Technical Memorandum

Project Number: 2018-66

Re: 151 Chapel Street – Transportation Addendum #4 (Version 3)

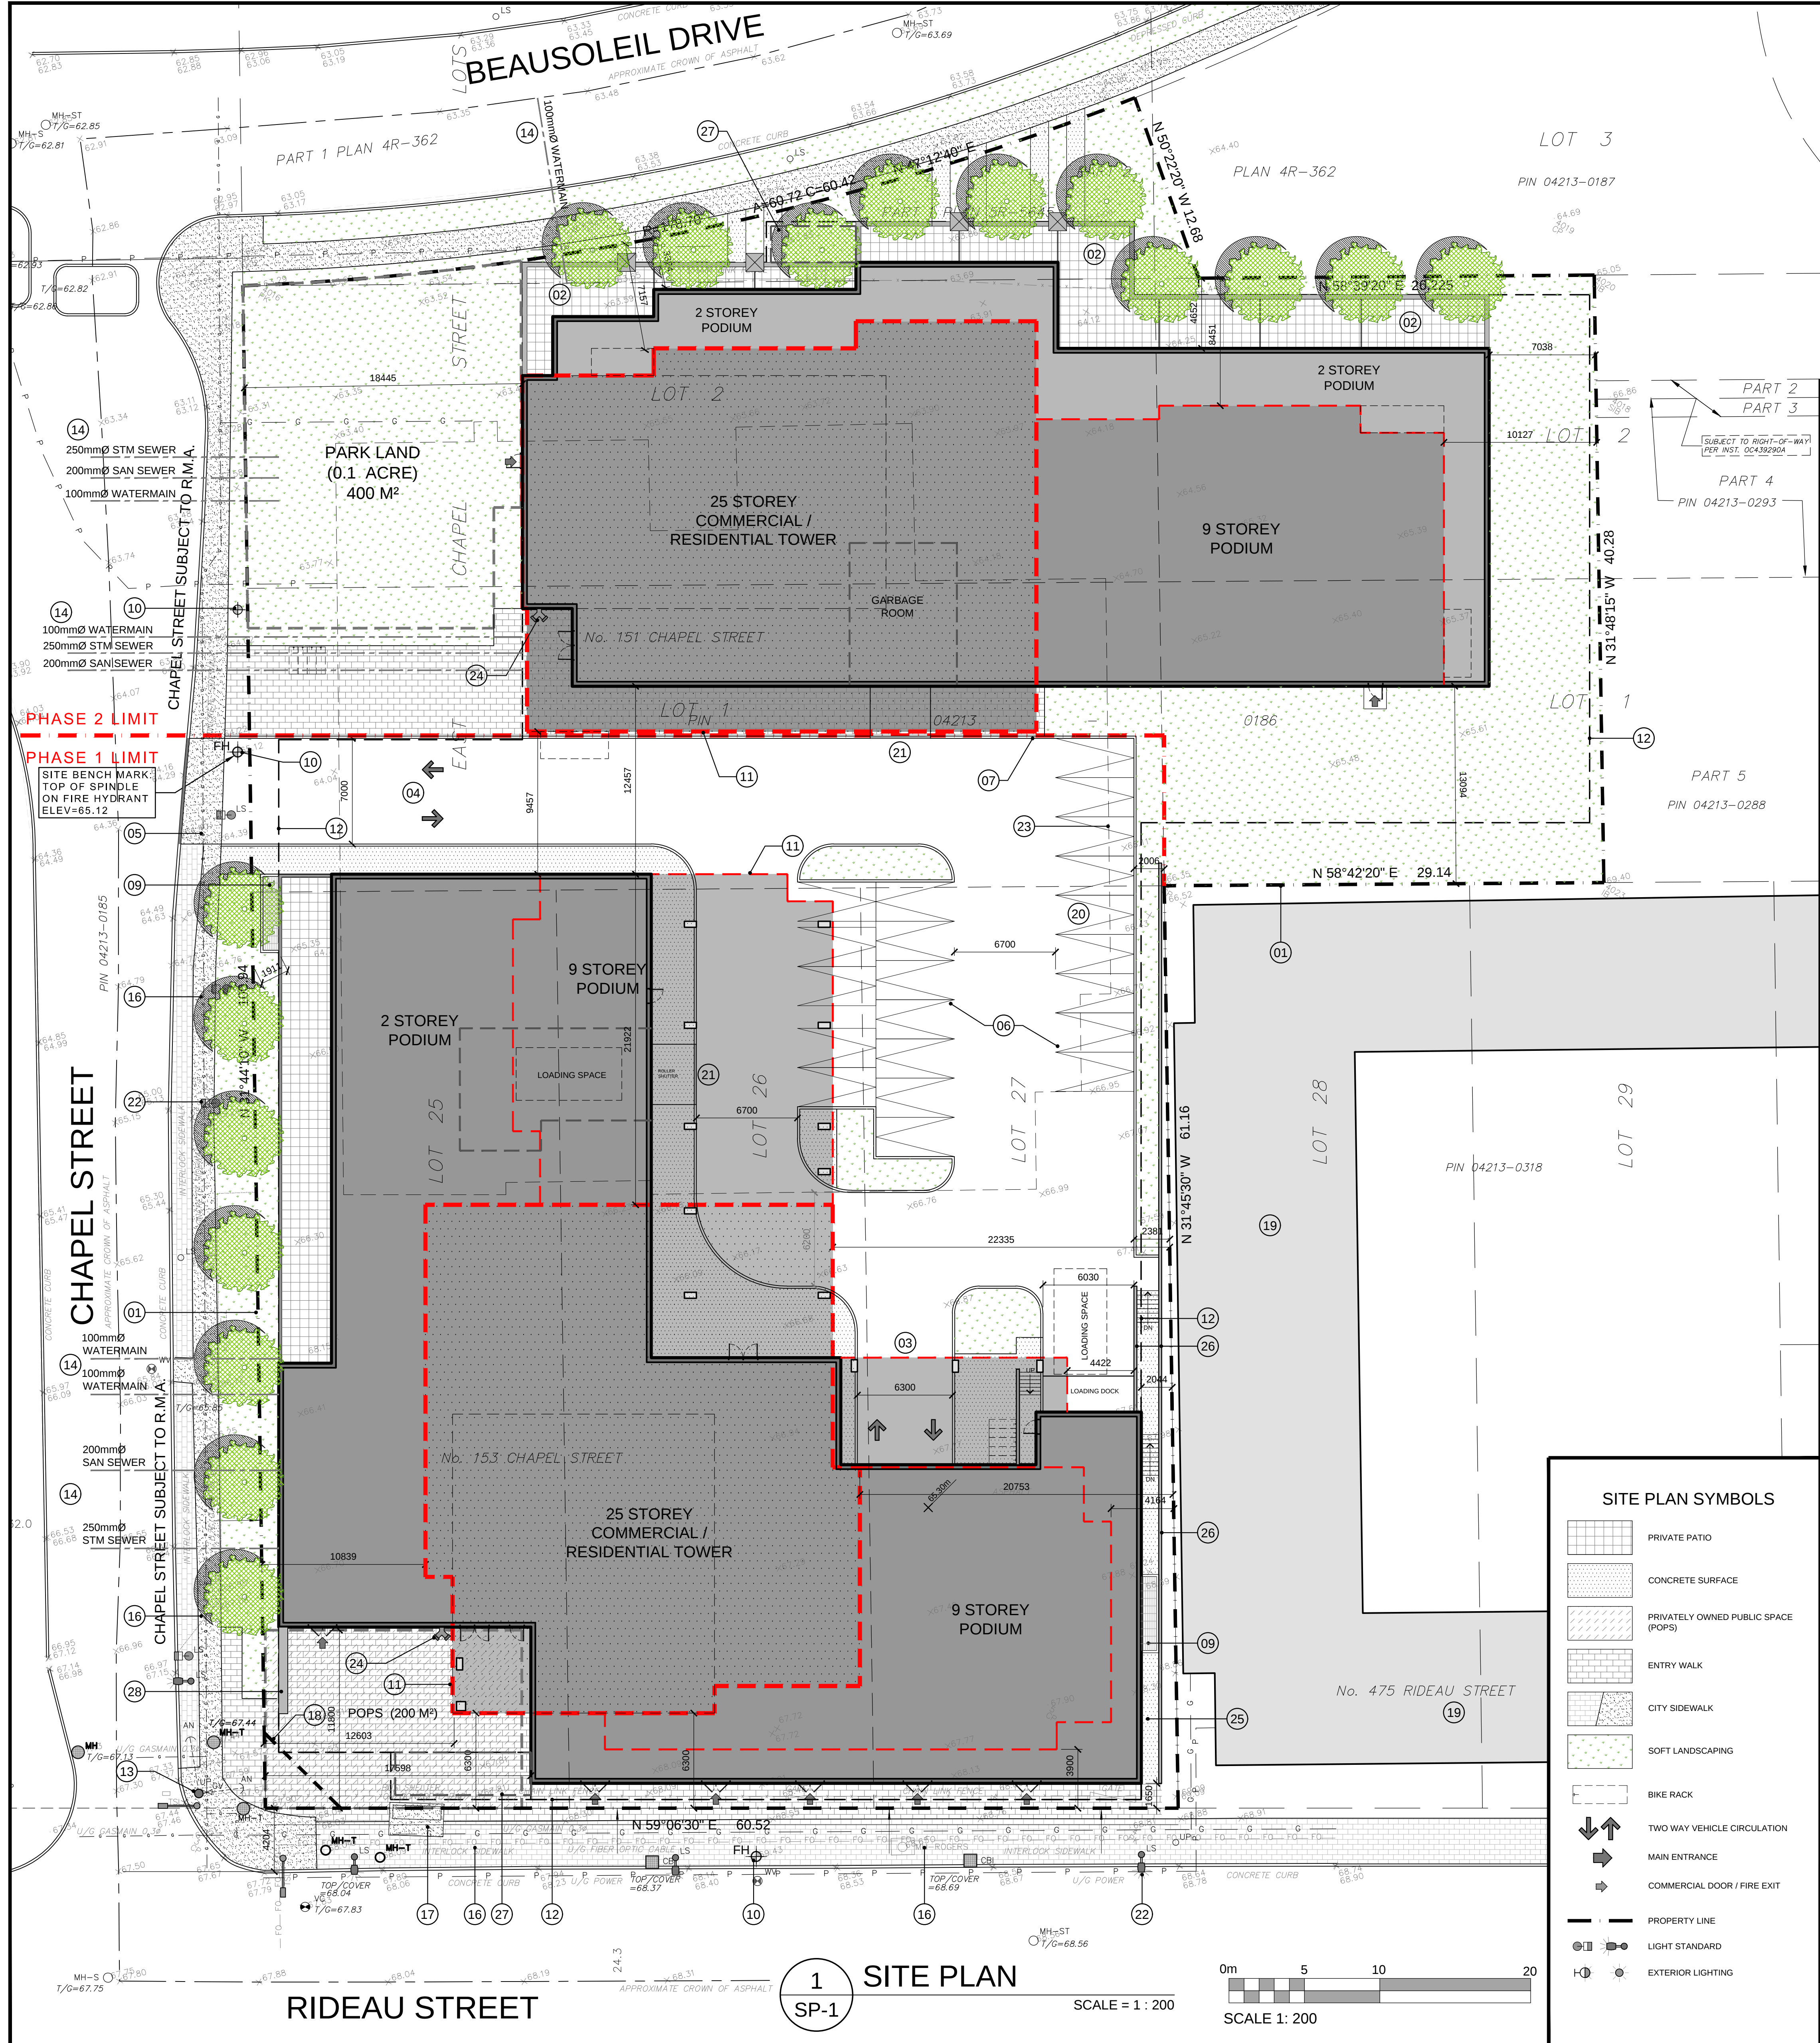
41. Clearly indicate the 13 m road widening from the existing center line on Rideau Street.	Noted on Site Plan drawings.
42. Complete the TDM checklists as indicated in the 2017 TIA Guidelines. Look for opportunities to reduce vehicle needs by encouraging alternative modes. In particular, review in detail access for cyclists. Cyclists require a safe and manageable access to their bicycles. Consider storage facilities at grade level or elevators that can accommodate bicycles to underground parking. Advise if car sharing spaces are anticipated in parking garage.	Section 6 of the CTS (2014) addresses TDM measures.
